PIKE SOLAR

GRADING, EROSION & SEDIMENT CONTROL PLANS

EPC STORMWATER REVIEW COMMENTS ARE SHOWN IN ORANGE BOXES WITH BLACK TEXT

PCD-ENGINEERING REVIEW COMMENTS IN BLUE BOXES WITH BLUE TEXT

PIKE SOLAR
EL PASO COUNTY, COLORADO
GRADING & EROSION CONTROL PLANS
INITIAL (3 OF 24)

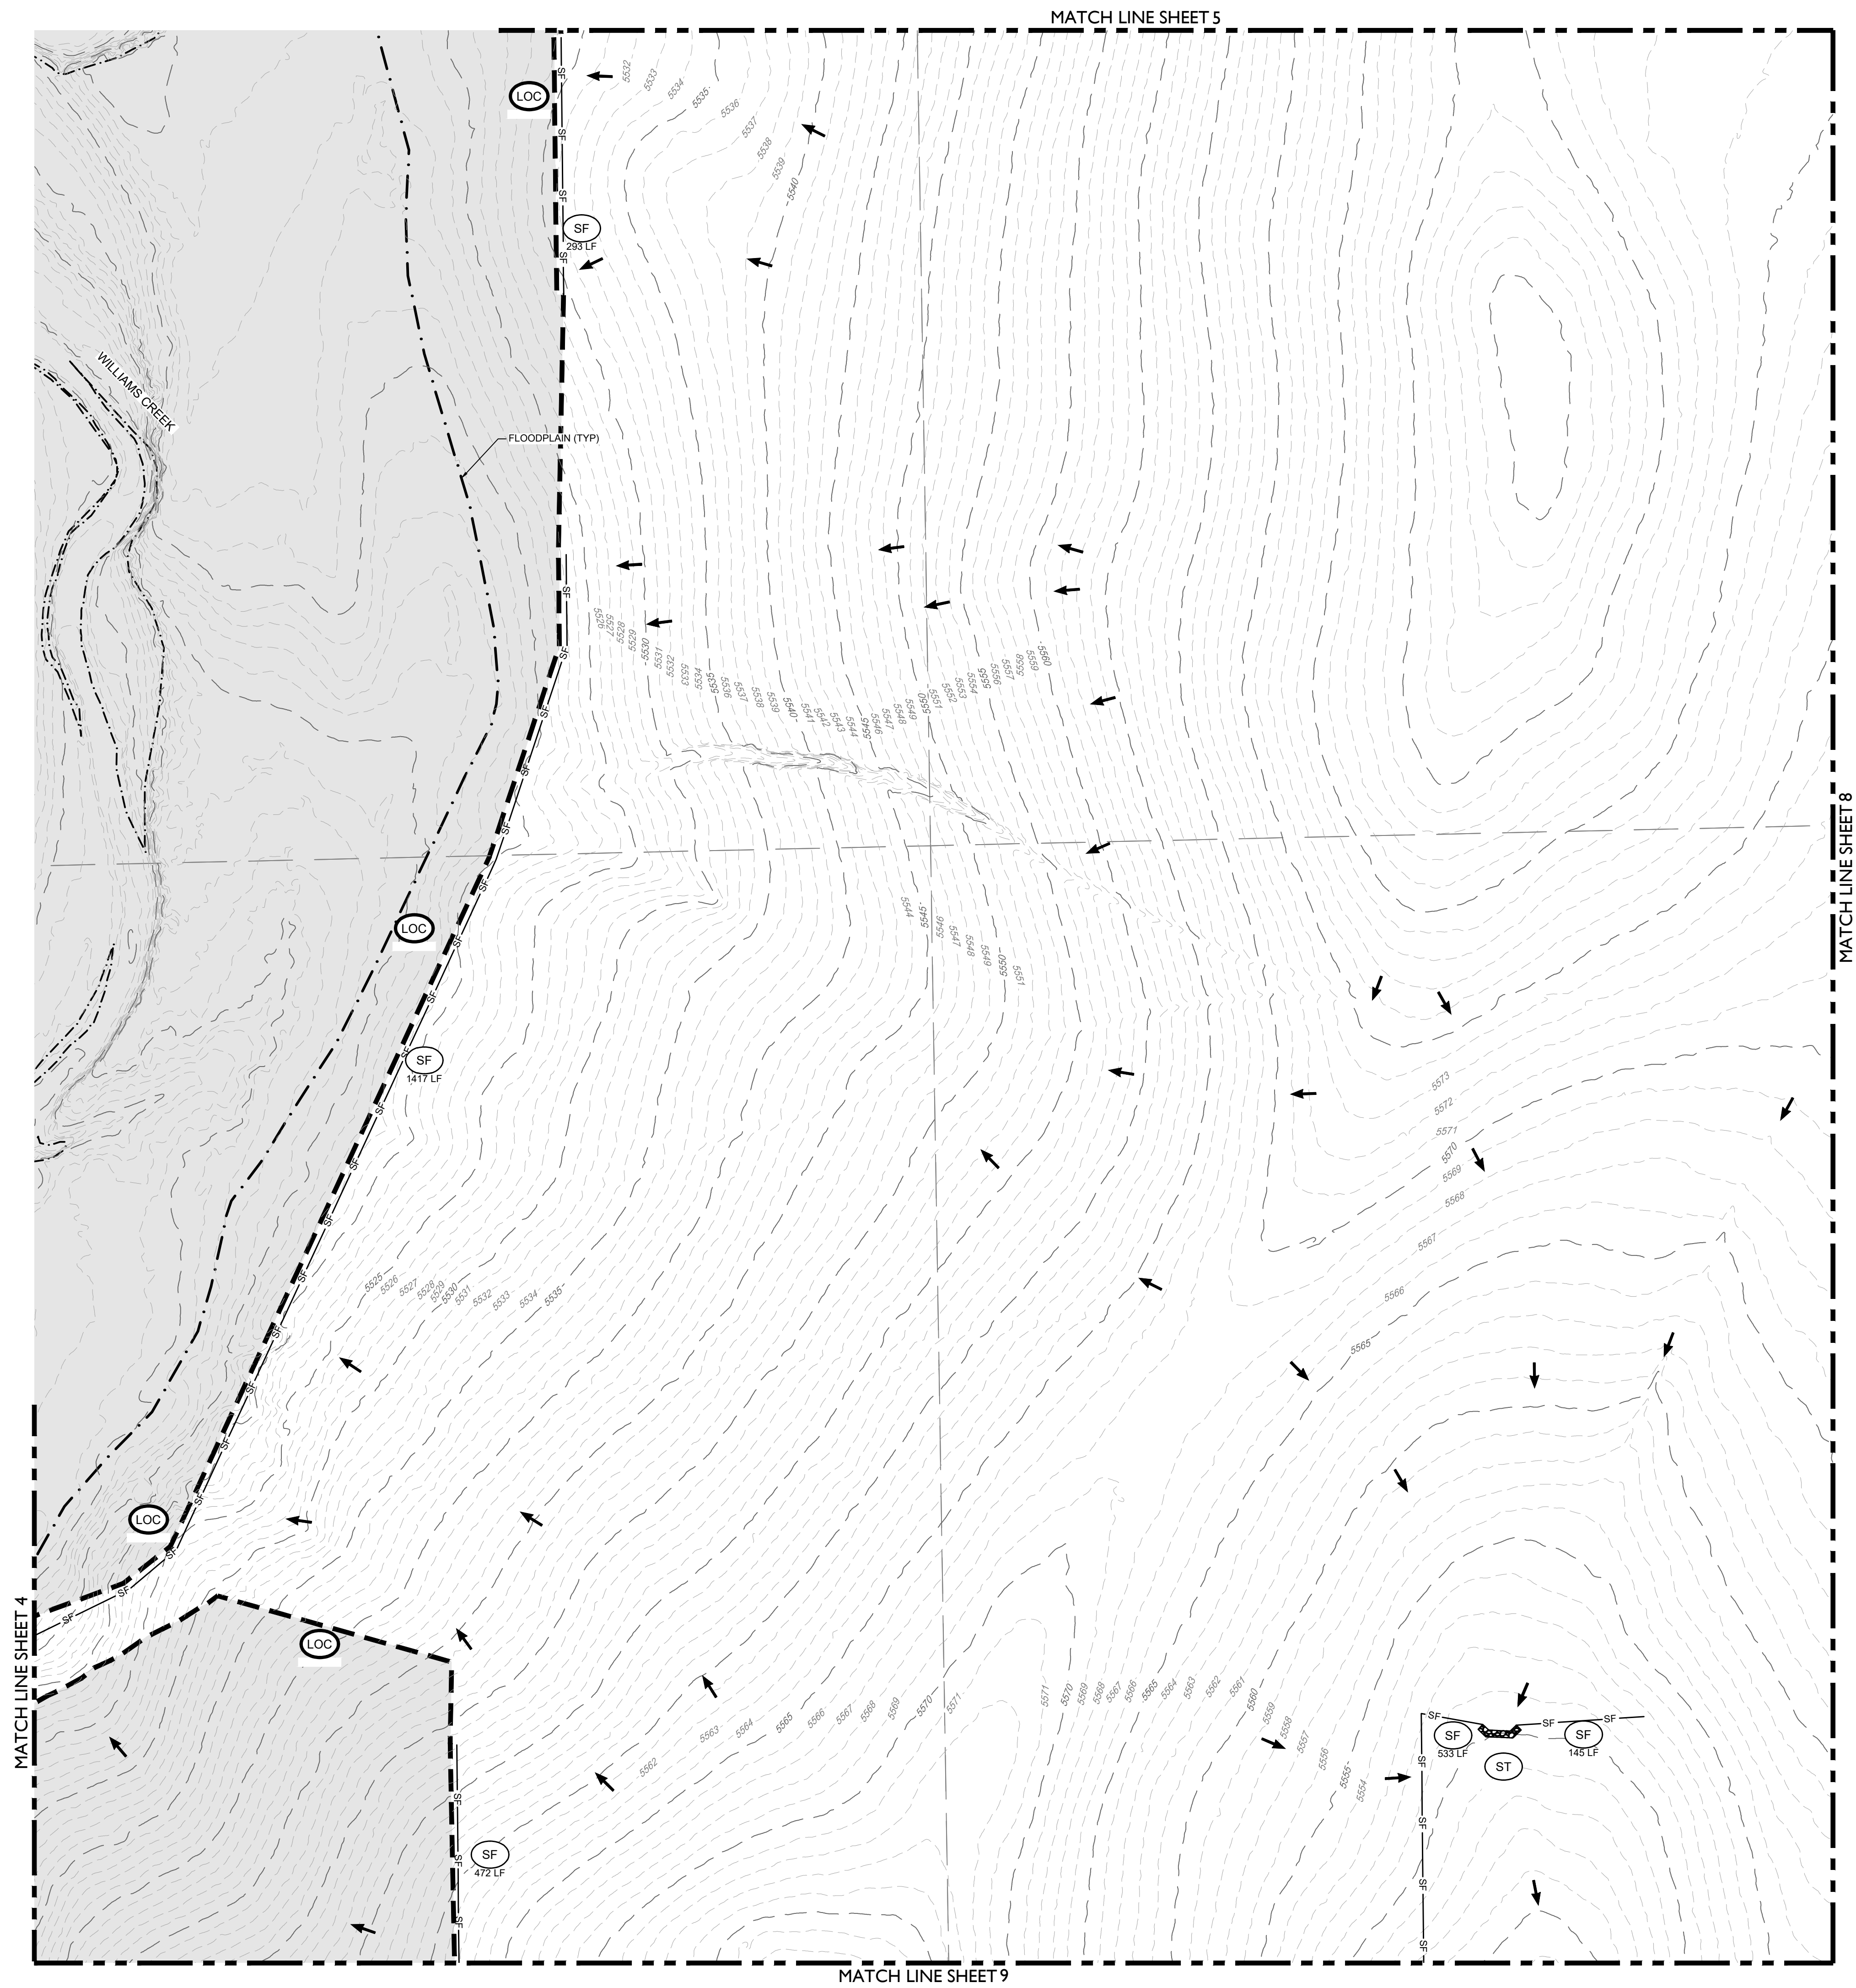
Sediment traps are not appropriate for this application. Temporary sediment basins should be used for tributaries greater than 1 ac. (typ.)

This sediment trap has been replaced with a temporary sediment basin.

PIKE SOLAR
 EL PASO COUNTY, COLORADO
 GRADING & EROSION CONTROL PLANS
 INITIAL (2 OF 24)

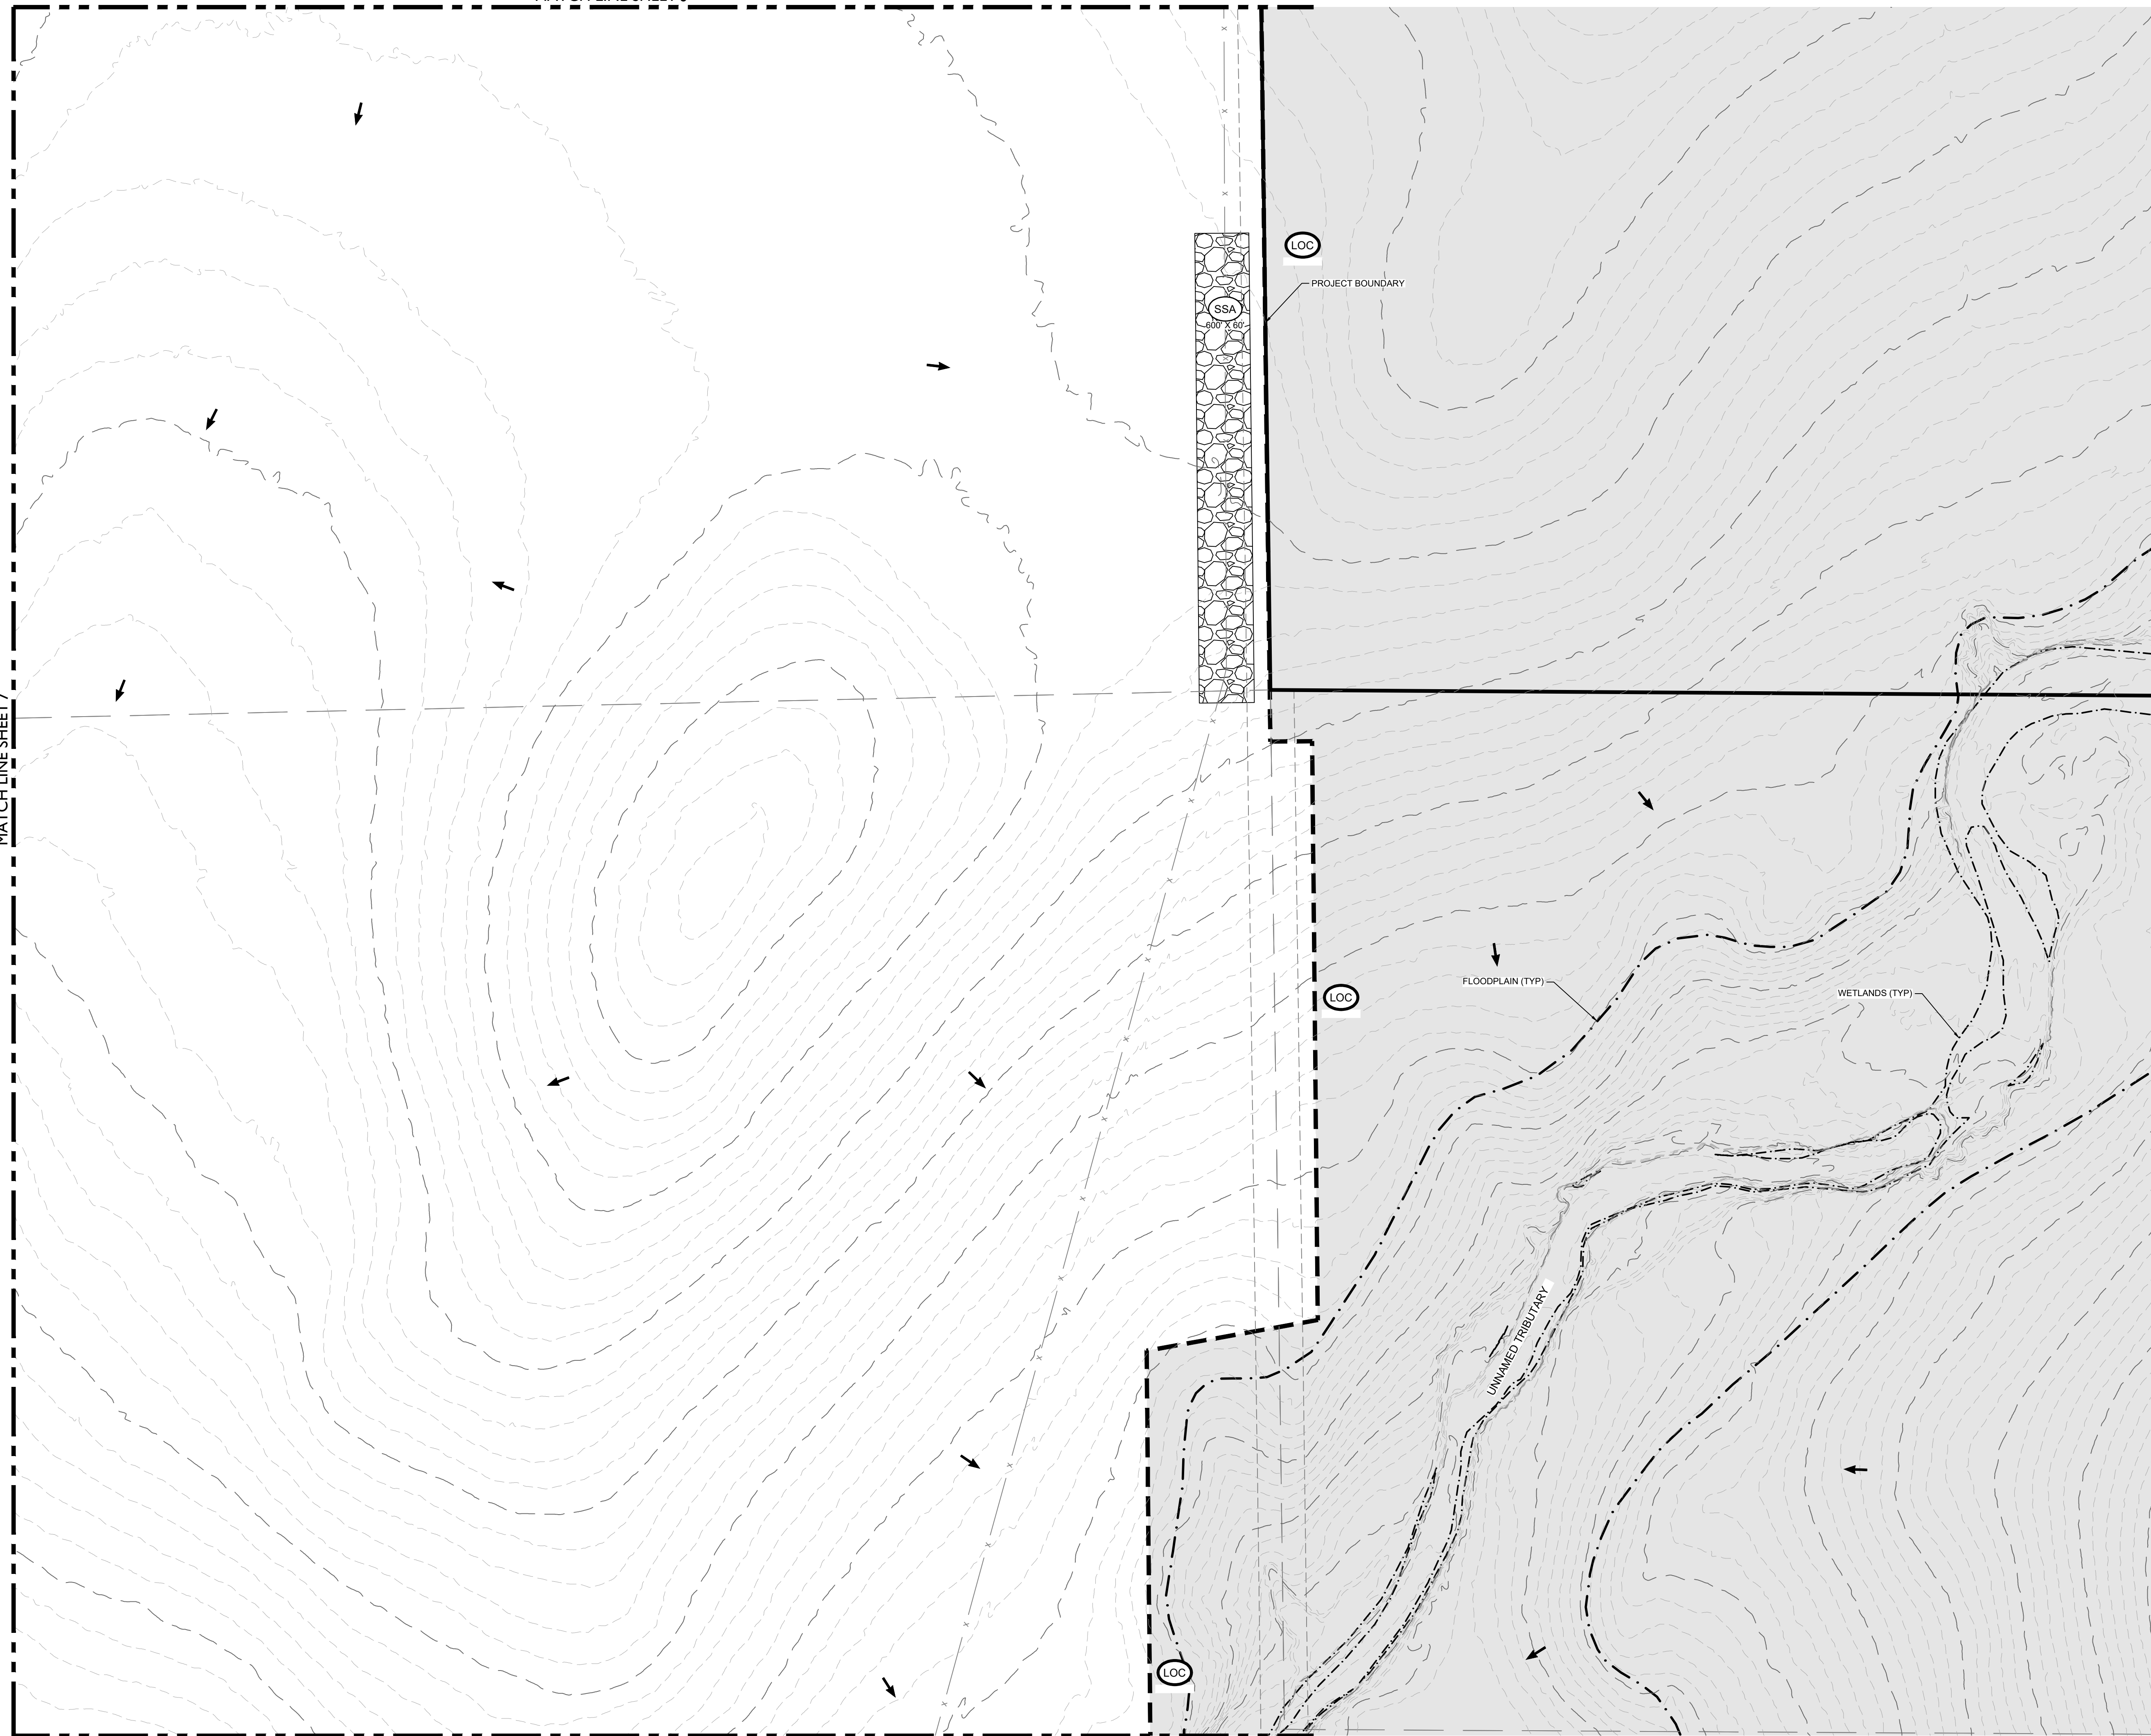
Silt fence should be parallel to contours. Placement as shown could channelize runoff.

A note has been added specifying silt fence to have J-hooks when it is not parallel to contours. This is also described in the silt fence detail.
